CITY OF ALBUQUERQUE

Re: Dash 4 Canna
1302 Broadway Blvd. NE
30-Day Temporary Certificate of Occupancy
Transportation Development Final Inspection
Architect's Stamp dated 04-09-24 (J14-D122)
Certification dated 06-07-24

SITE PLAN

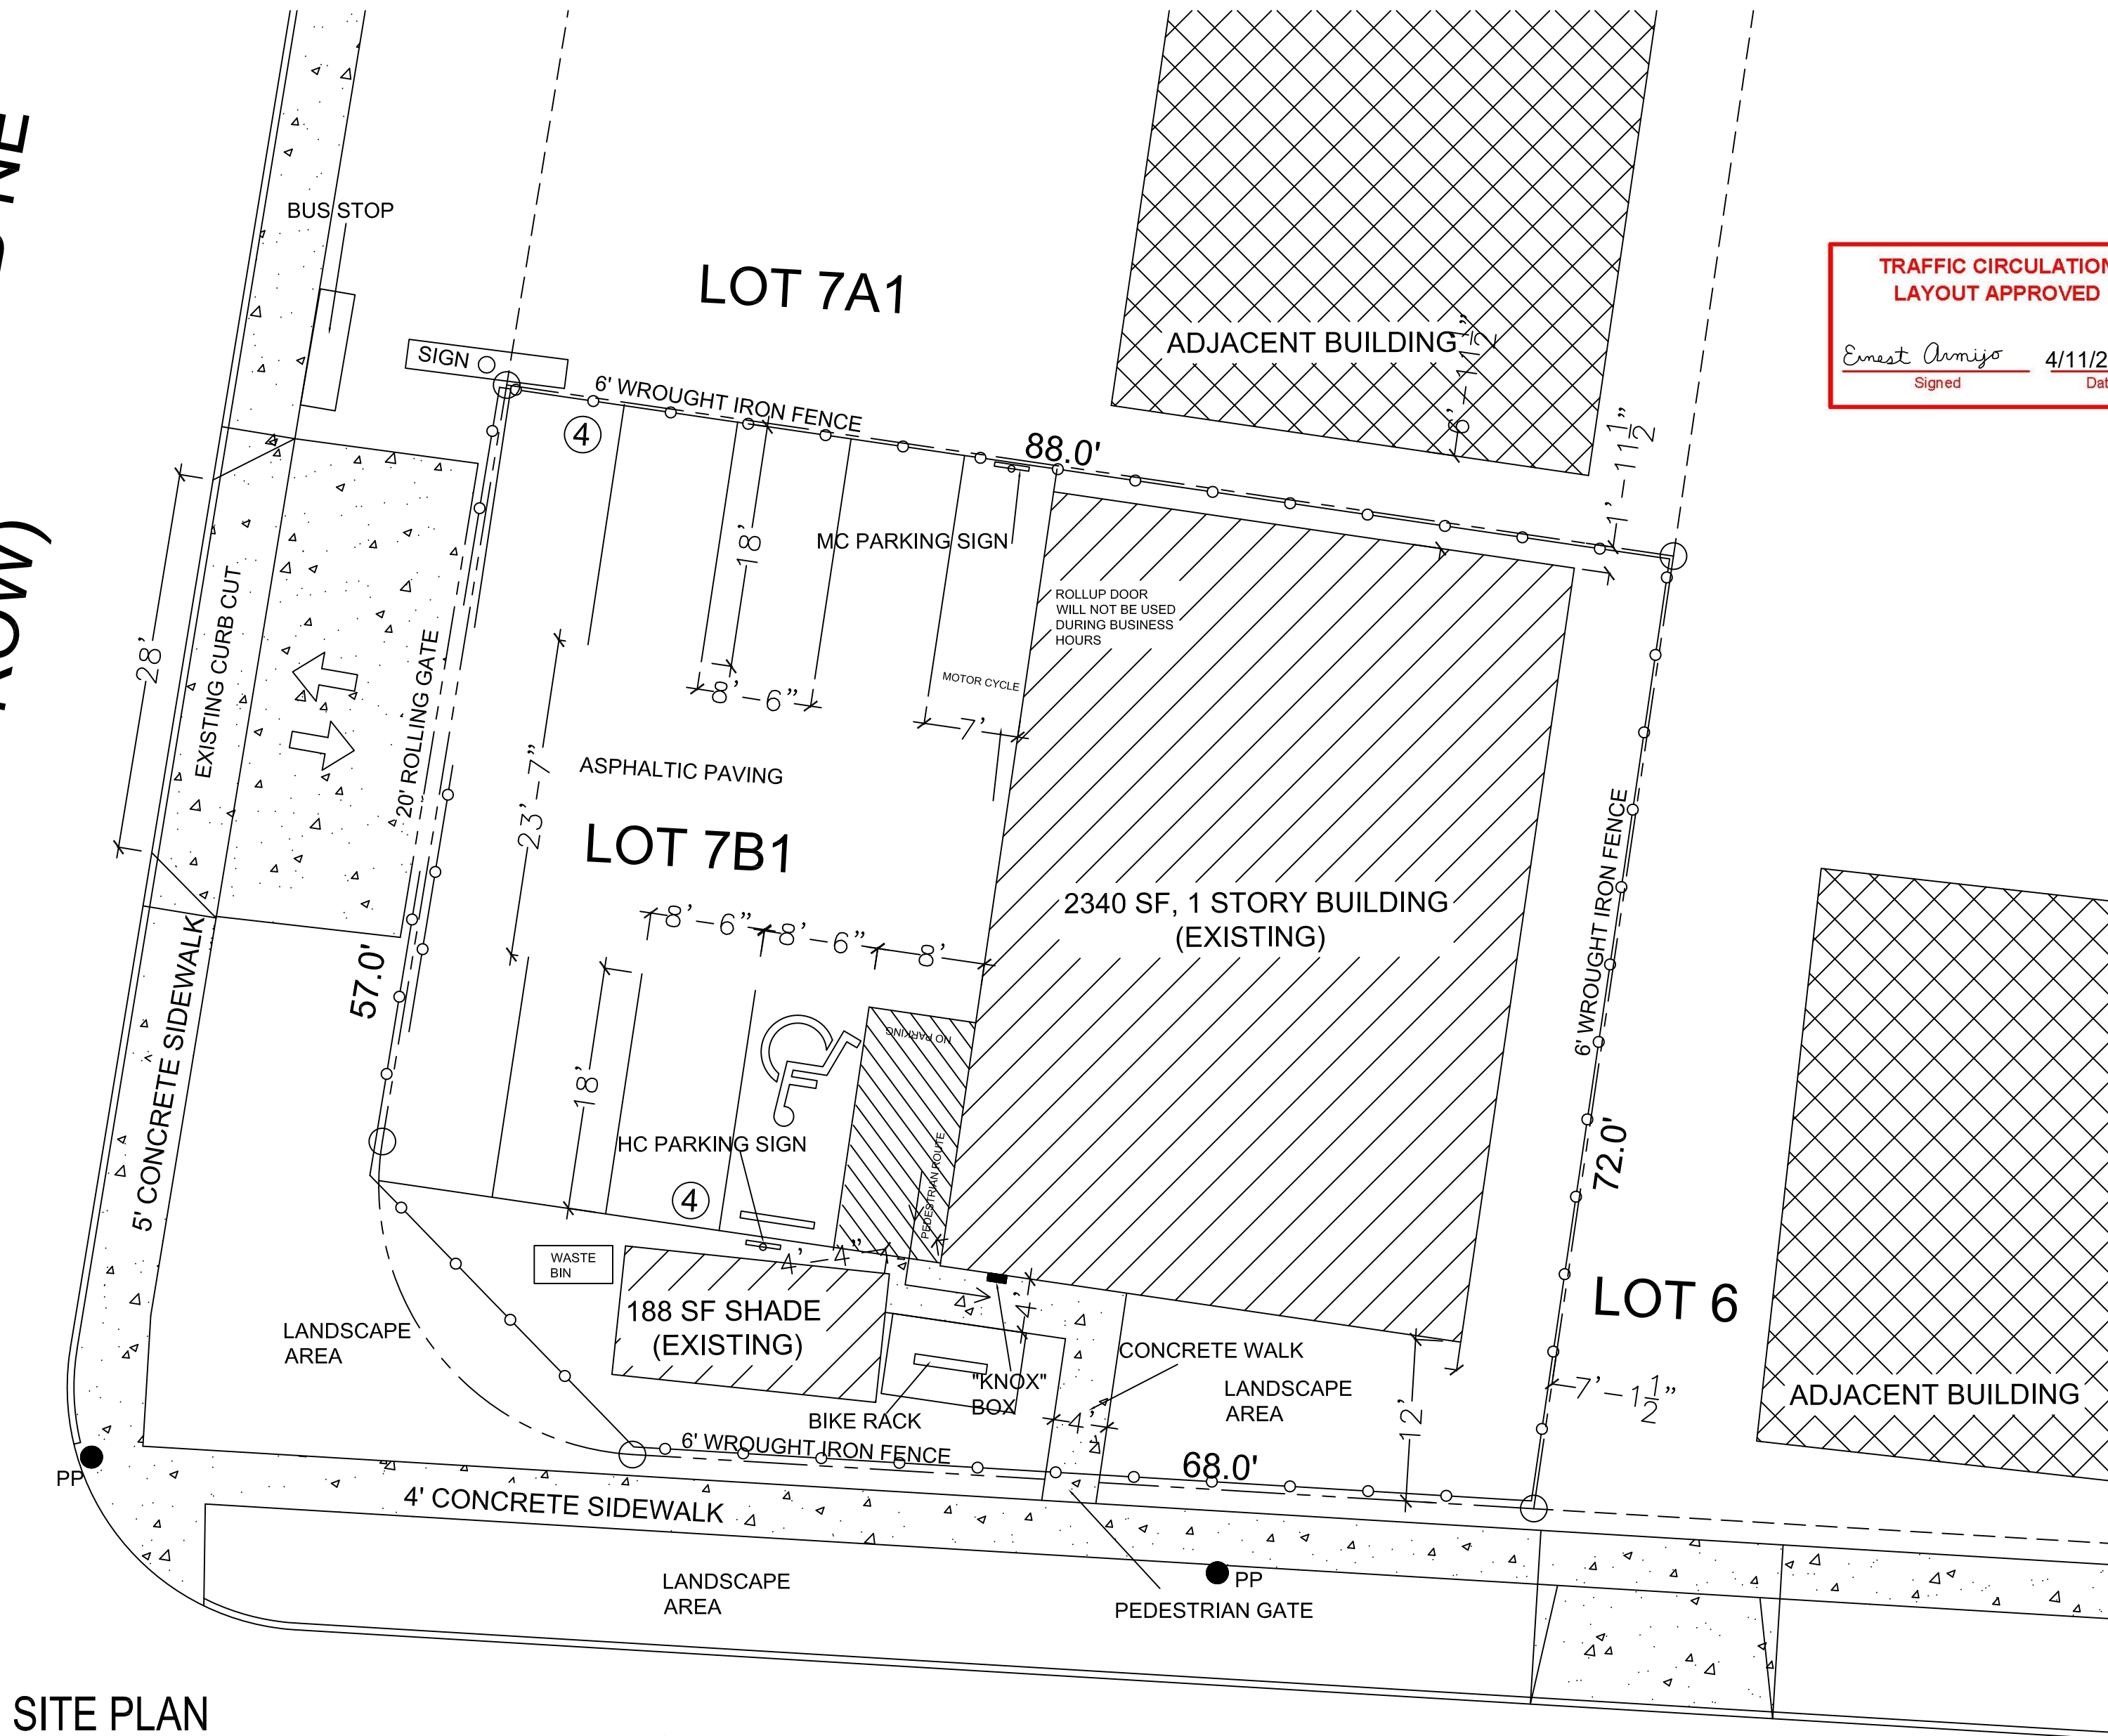
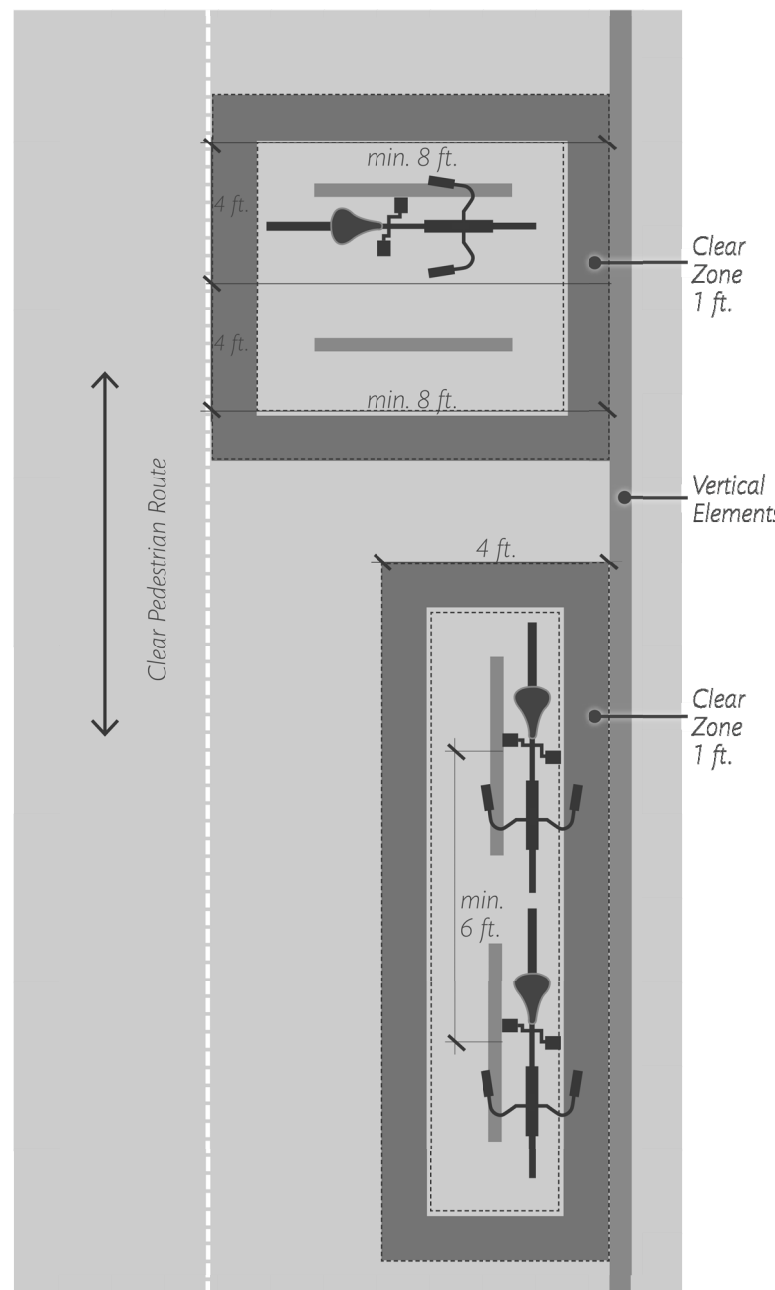
- Per the approved site plan: The pedestrian pathway from the public sidewalk to the entrance, must be constructed.
